West Burton C (Gas Fired Generating Station)

Appendix 1C: Matters Addressed from Scoping Opinion

EDF Energy (Thermal Generation) Limited

April 2019

Figure 2: Landscape and Biodiversity Enhancement Proposals

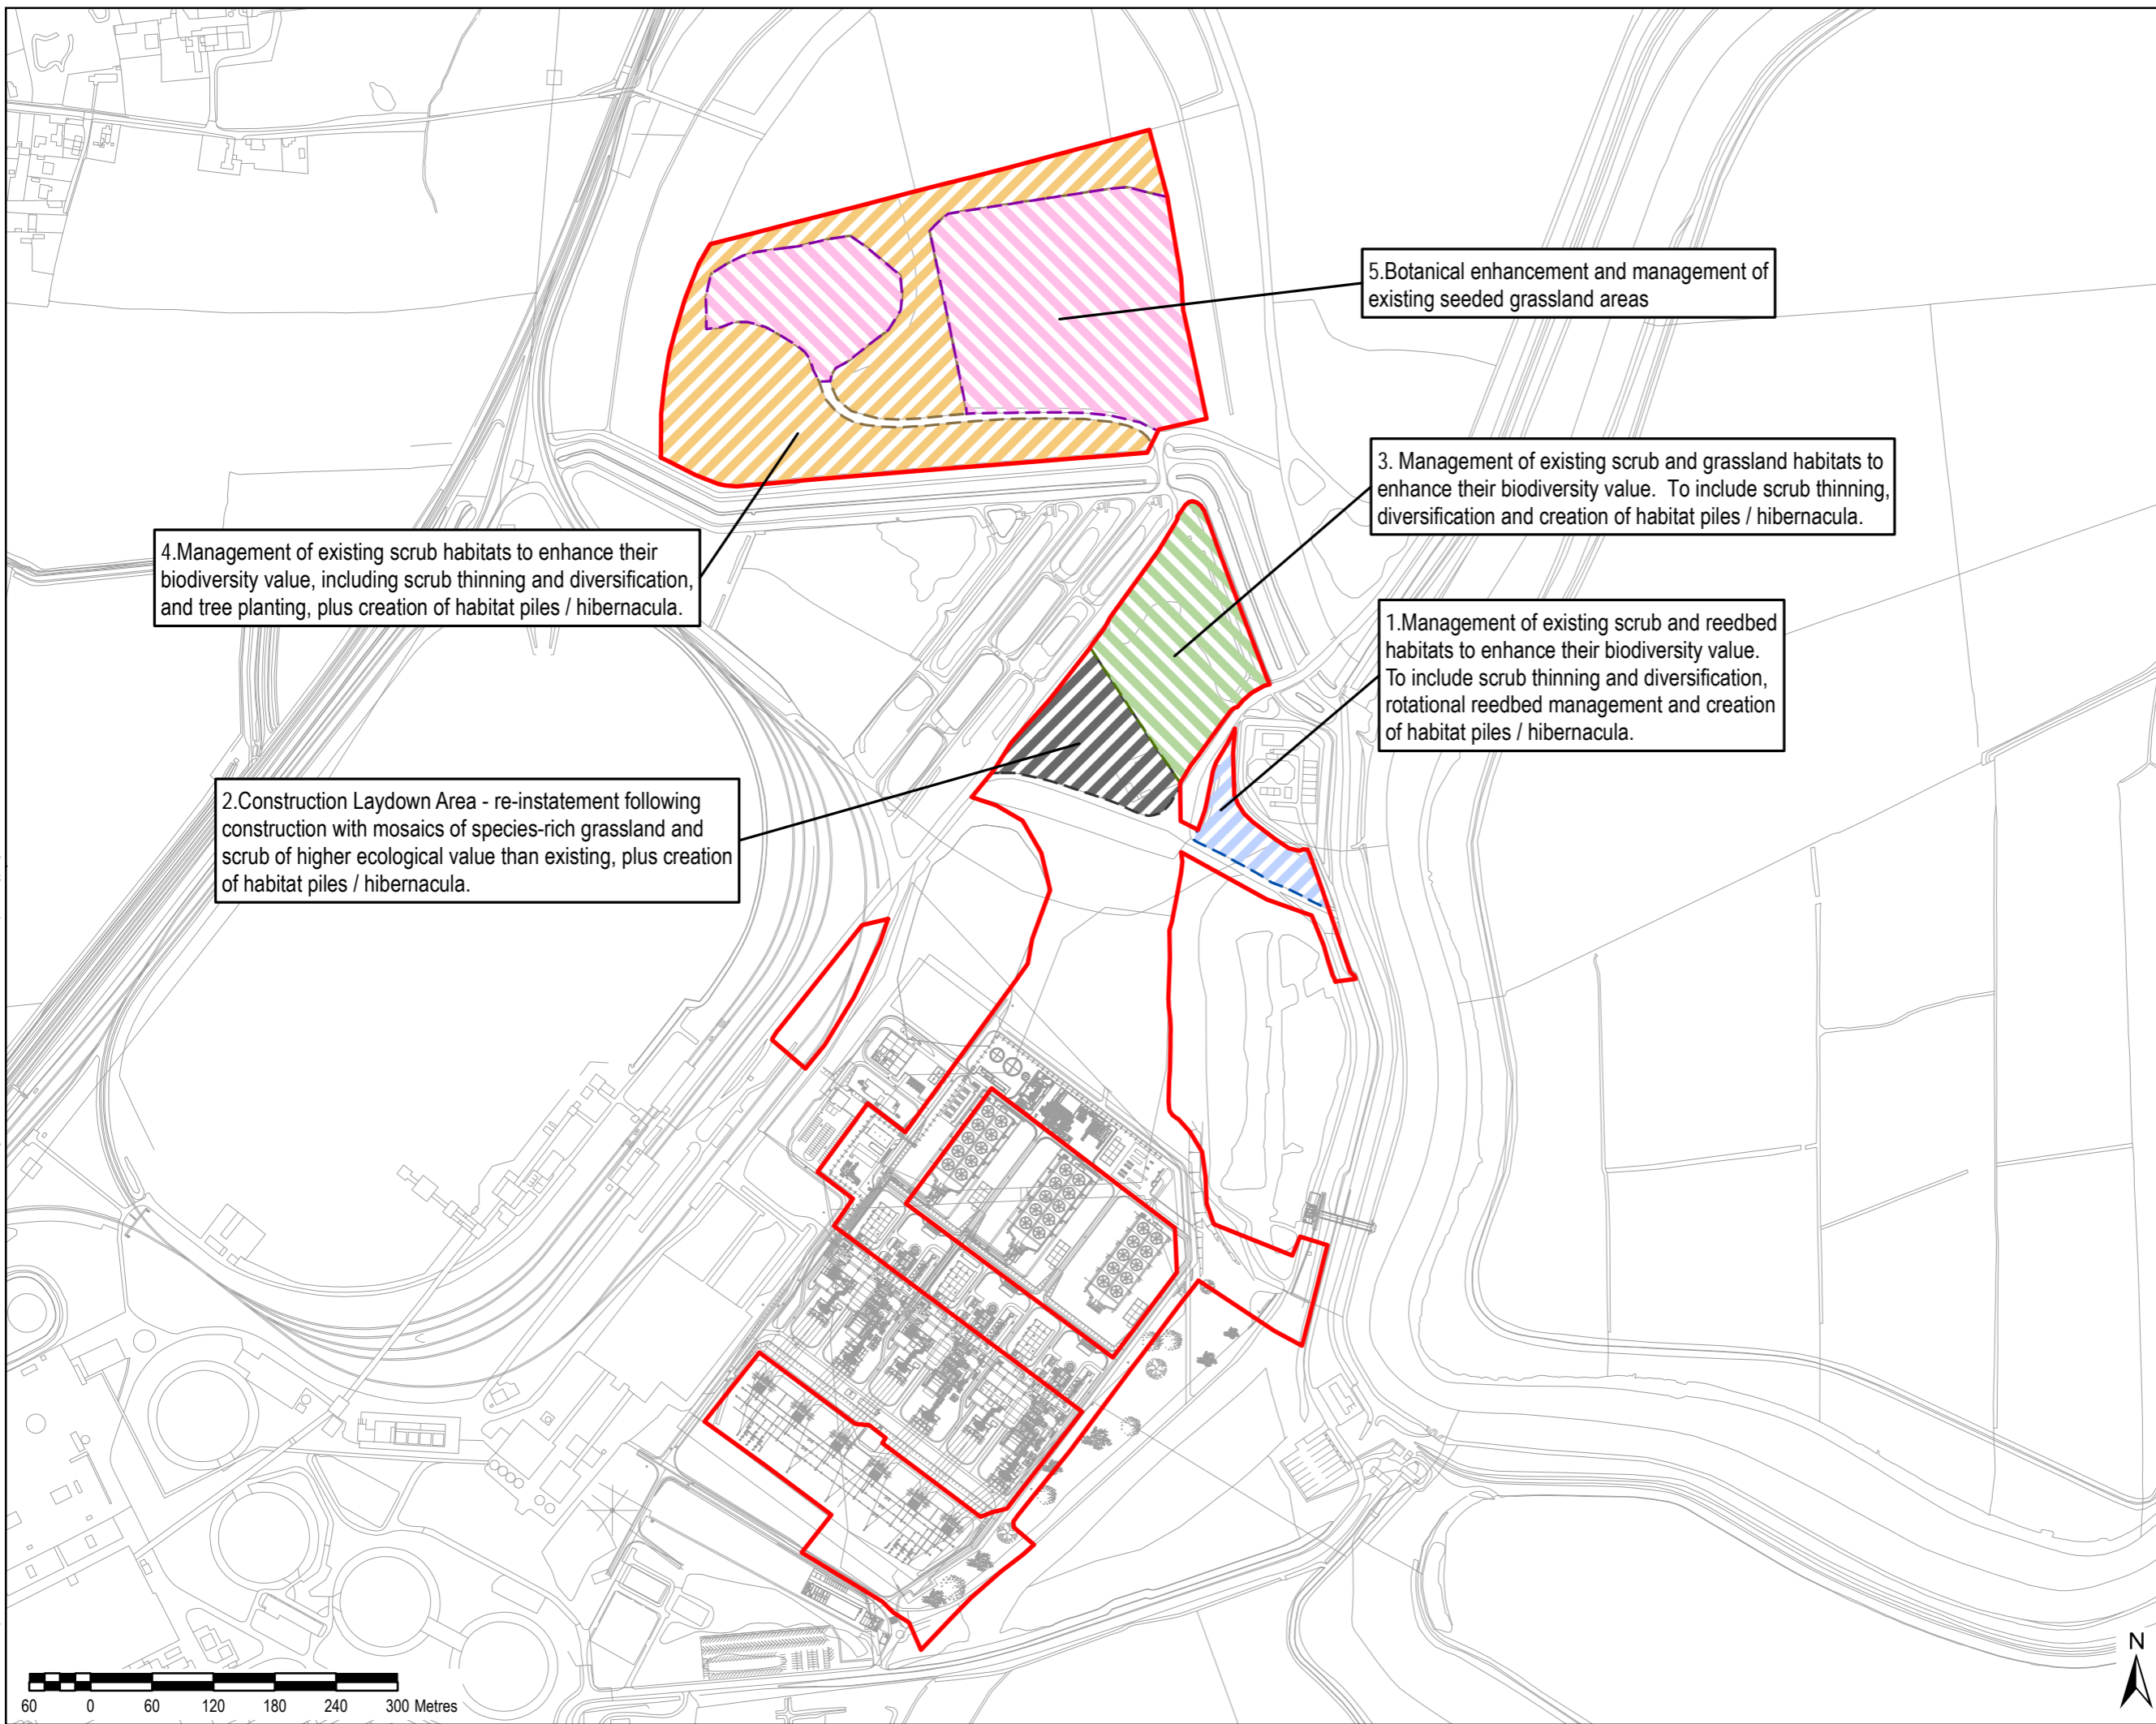
Chapter 9: Ecology and	MMO	River habitats	Need to consider effects on habitats and species associated	Chapter 9: Ecology (ES Volume I) does not include consideration and

Chapter	Consultee	Topic	Summary of Scoping Opinion Comment	Summary of Response
Nature Conservation			with River Trent, particularly for proposed outfalls and impacts of any dredging. MMO provided comments regarding the need to address effects on marine ecology.	assessment of impacts on aquatic ecology as the new outfall to River Trent option is no longer being pursued – therefore, no effects on fish or other aquatic species are predicted.
	Nottinghamshire County Council (NCC)	Habitat loss calculation	NCC request that a 'biodiversity accounting' approach to calculate direct habitat loss.	The Defra offsetting metric has been used to quantify the loss of biodiversity as a result of the Proposed Development and to determine the requirement for habitat restoration/creation to ensure no net loss and a small net gain of biodiversity. Further information is provided in Chapter 9: Ecology (ES Volume I) and Application Document Ref. 7.5: Landscaping and Biodiversity Management and Enhancement Plan whilst proposed ecological mitigation areas are shown on Figure 9.1 (ES Volume III) .
